From: Lauren Wiltshire [REDACTED]
Sent: 24 April 2019 13:43
To: Laura Gibbons <Laura.Gibbons@arun.gov.uk>
Cc: Simon Davis <Simon.Davis@arun.gov.uk>
Subject: RE: Planning Consultation on FP/42/19/DOC

Engineers Comments Regarding Condition 7

NB: Sub-base construction depths are shown as minimum construction requirements. Specific construction depths vary, e.g. where sub-base falls (to collection point) in opposite direction to surface falls. See respective Drainage Layout for specific sub-base levels.

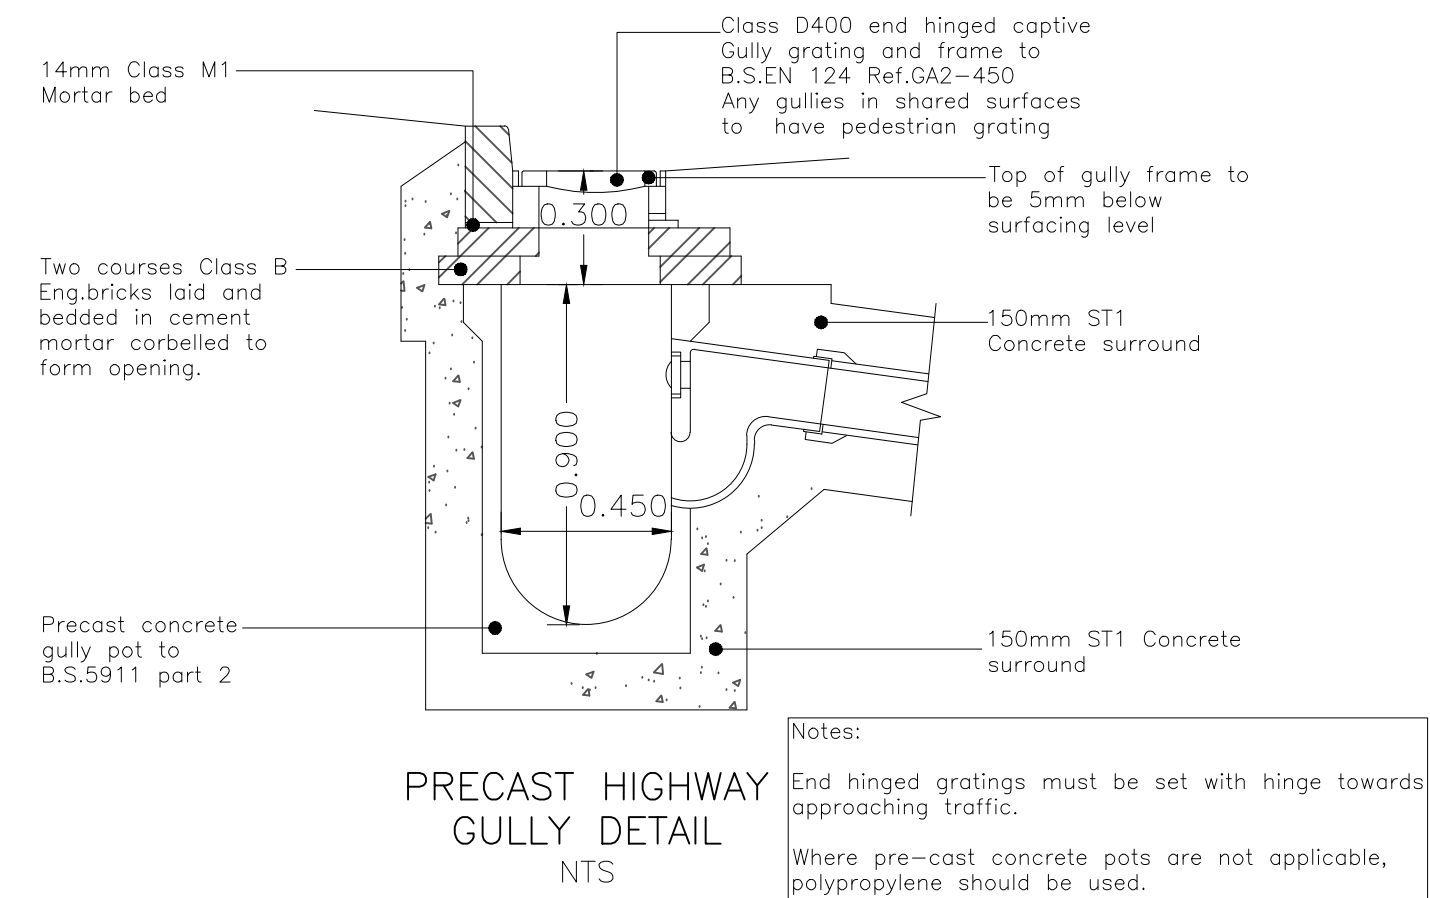
1. Catchpits must be provided upstream of all connections into the attenuation tank.
2. No construction detail drawings have been provided. Please provide construction detail drawings of manholes, catchpits, permeable paving, attenuation tank and hydrobrake.
3. There is conflict between the landscaping proposals and the drainage proposals. Trees must not be located on or near attenuation tanks. Please revise the landscaping proposals.
